Immingham Green Energy Terminal

10.7 Proposed Further Changes Notification Report

May 2024

Document Reference: TR030008/EXAM/10.7

Site Boundary & Works Plans Changes between DCO Application (September 2023) & Change Application (March 2024) Key Plan

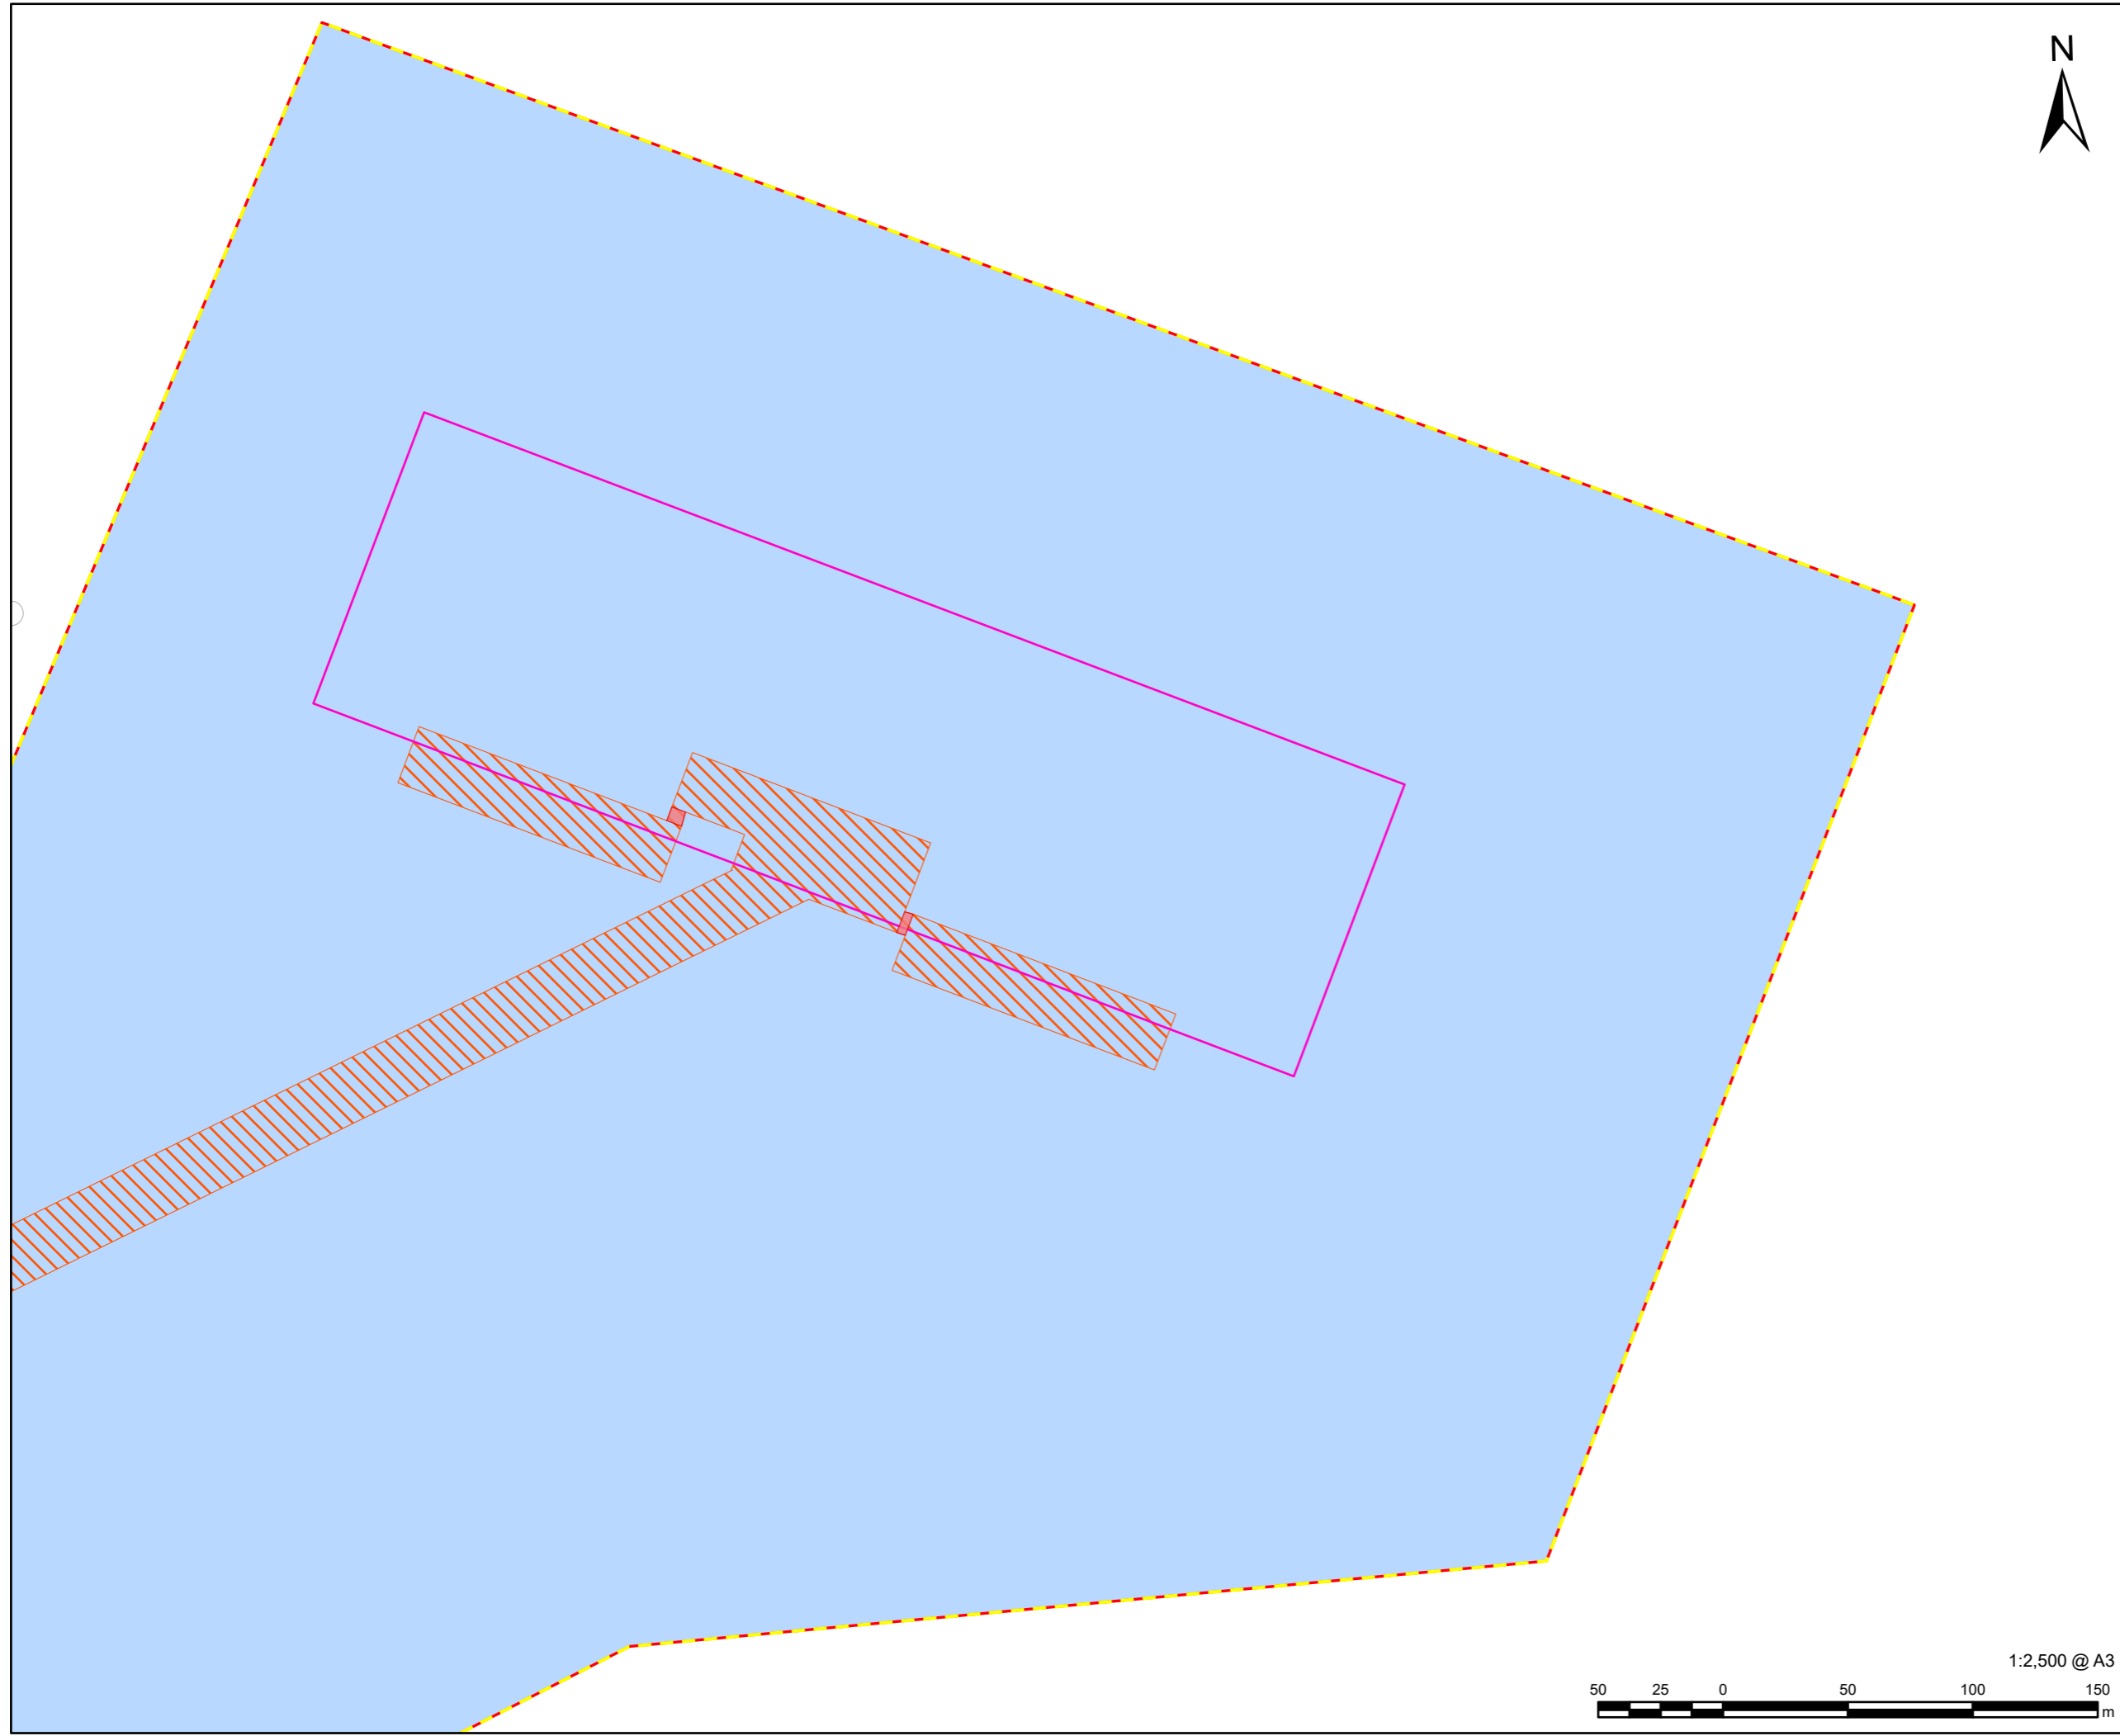
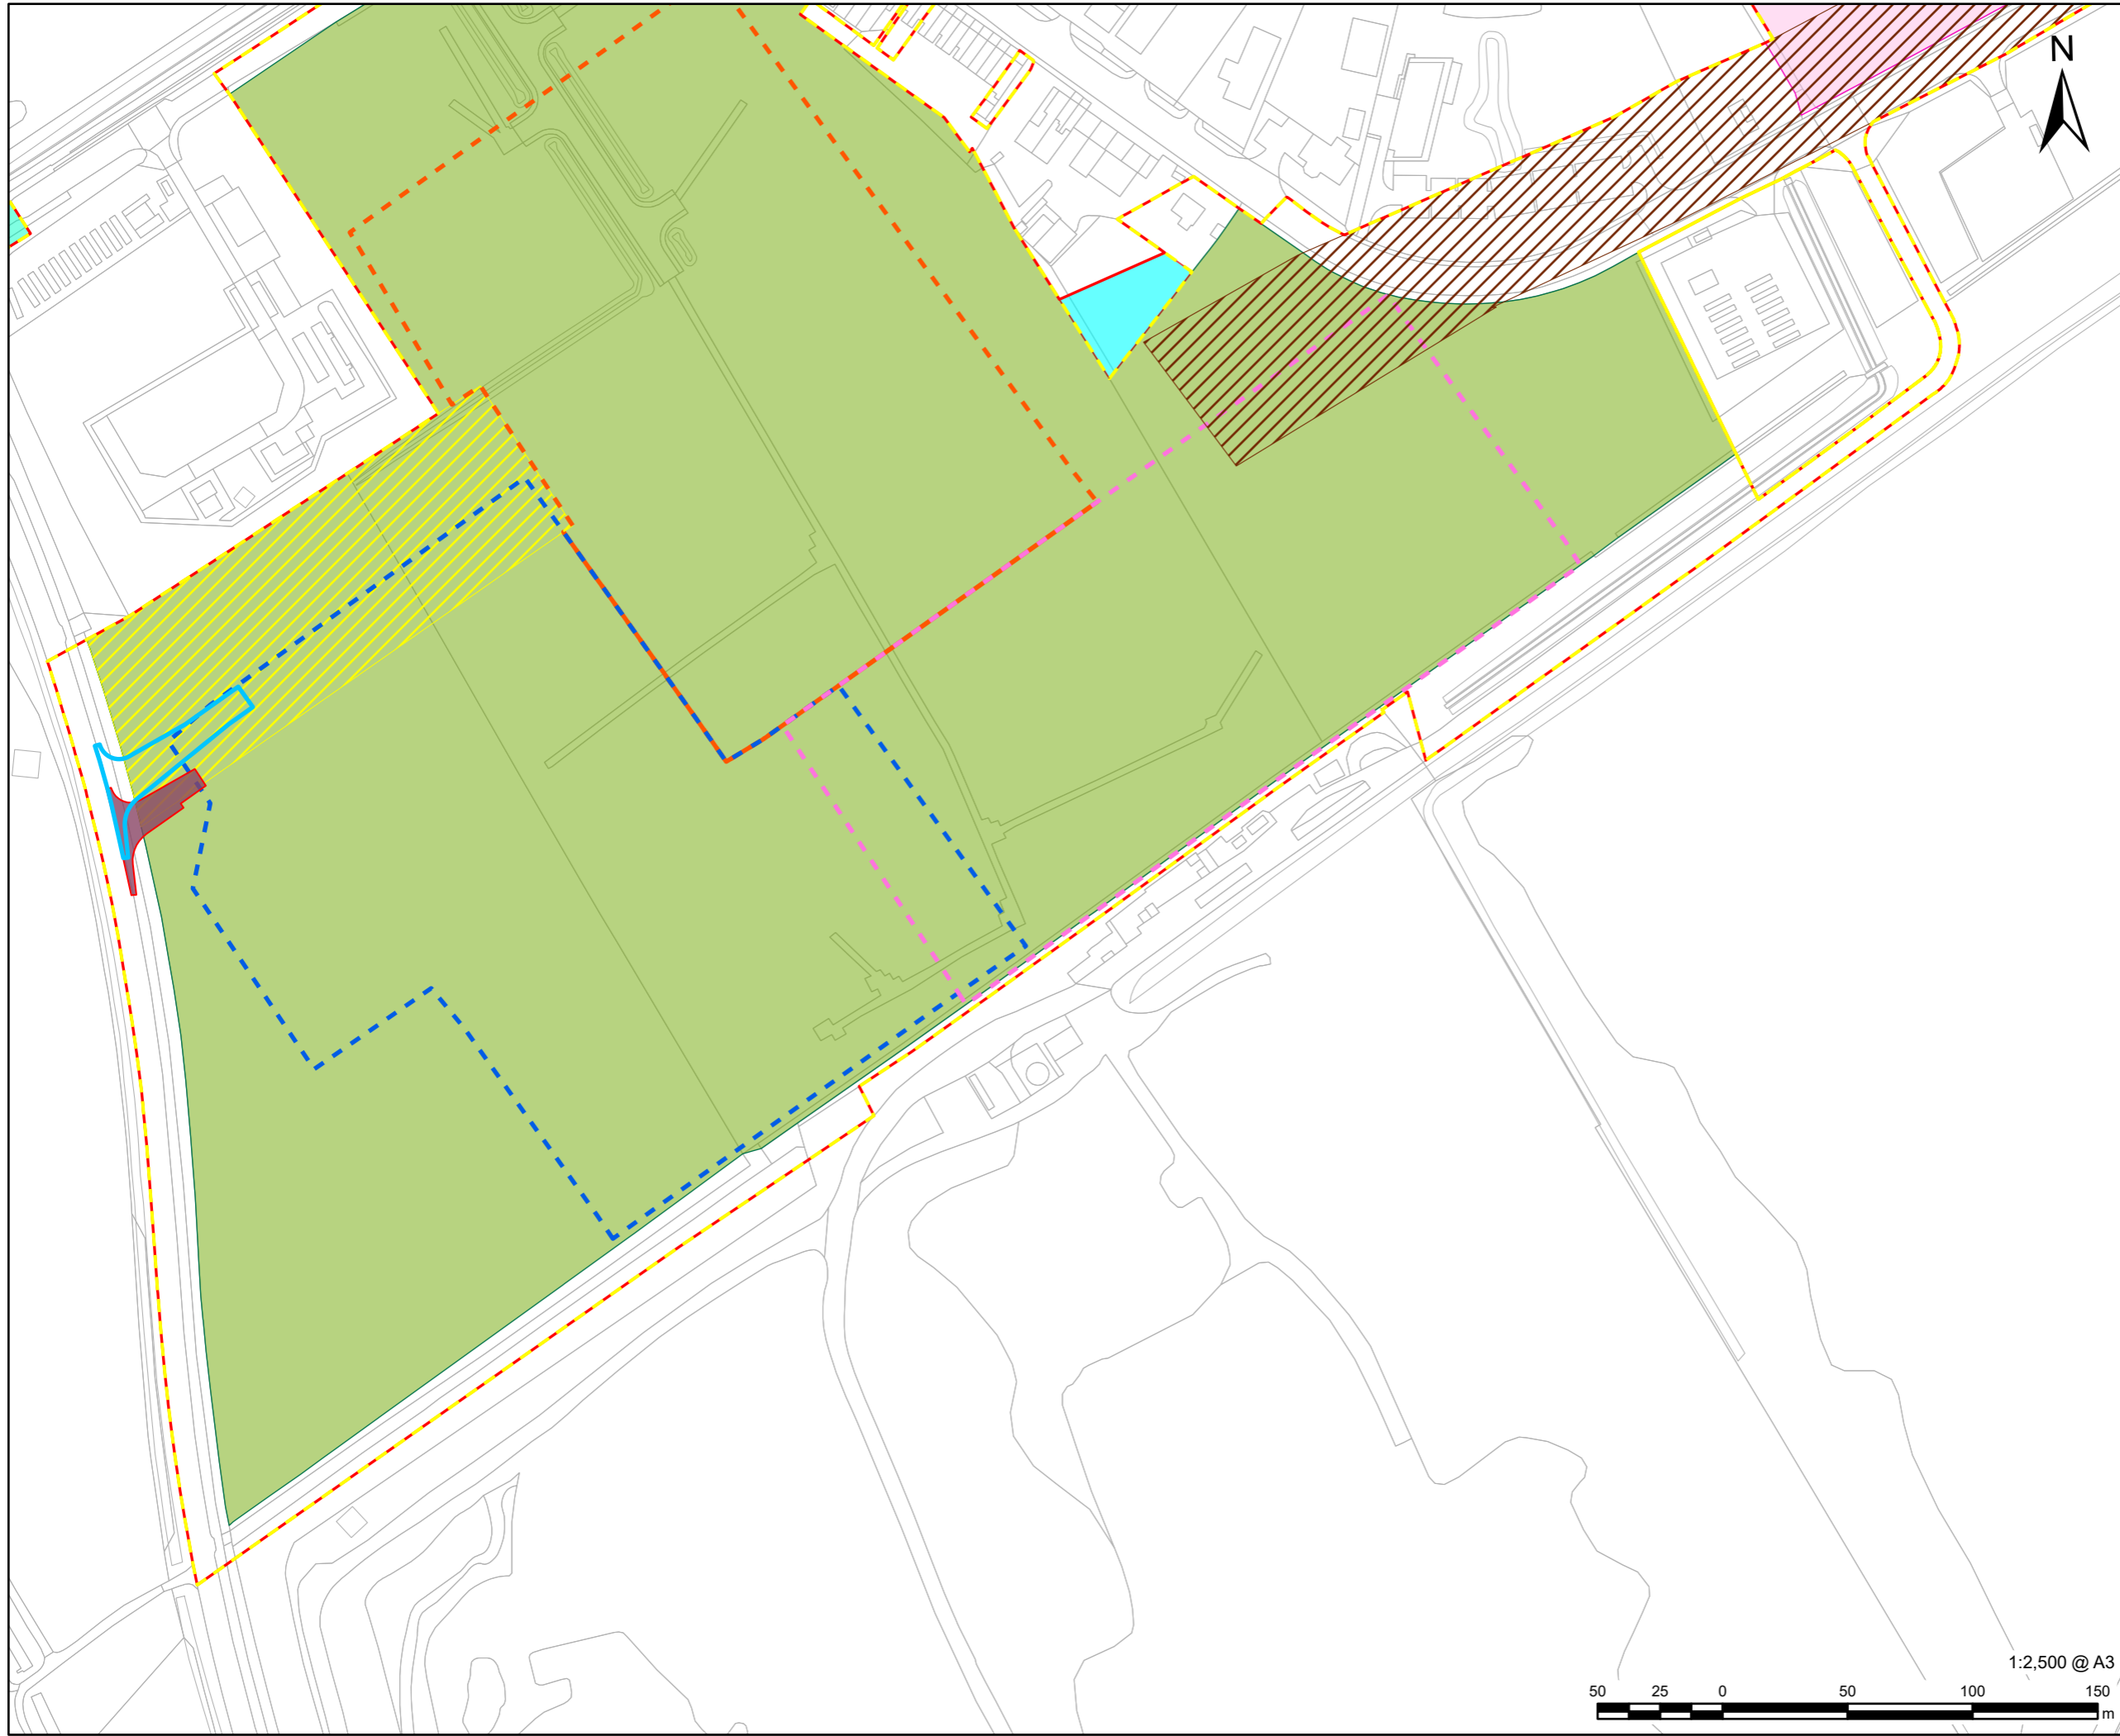
- 2.7 Proposed Change 7: reduction in area of Work No. 9 & Order limits
- 2.7.1 Proposed Change 7 consists of a beneficial reduction in the area of Work No. 9 (2.64 ha). Work No. 9 is proposed to be used for temporary construction purposes and temporary possession powers are sought in relation to Work No. 9 during the construction period.

- 2.7.2 The reduction in Work No. 9 is proposed following engagement with two parties. First, the Environment Agency has indicated that there is a small area of Work No. 9 close to the North Beck Drain which is liable to flood and so should not be used for construction purposes. Additionally, during engagement with the owner of part of Work No. 9 on the terms of an agreement for lease of that land, the owner expressed a desire to retain possession of a particular part of the land for its own purposes. After further review of the land required for construction purposes based on latest information, the Applicant has concluded that these requests can be accommodated and have the benefit of enabling the reduction of the area required for Work No. 9, and also the Order limits, as well as reducing the area subject to powers of temporary possession in connection with the Project.

- 2.7.3 **Appendix 1** illustrates the location of the proposed change and **Appendix 2** illustrates the reduction in the Order limits as a result of the reduction in the area of Work No. 9.
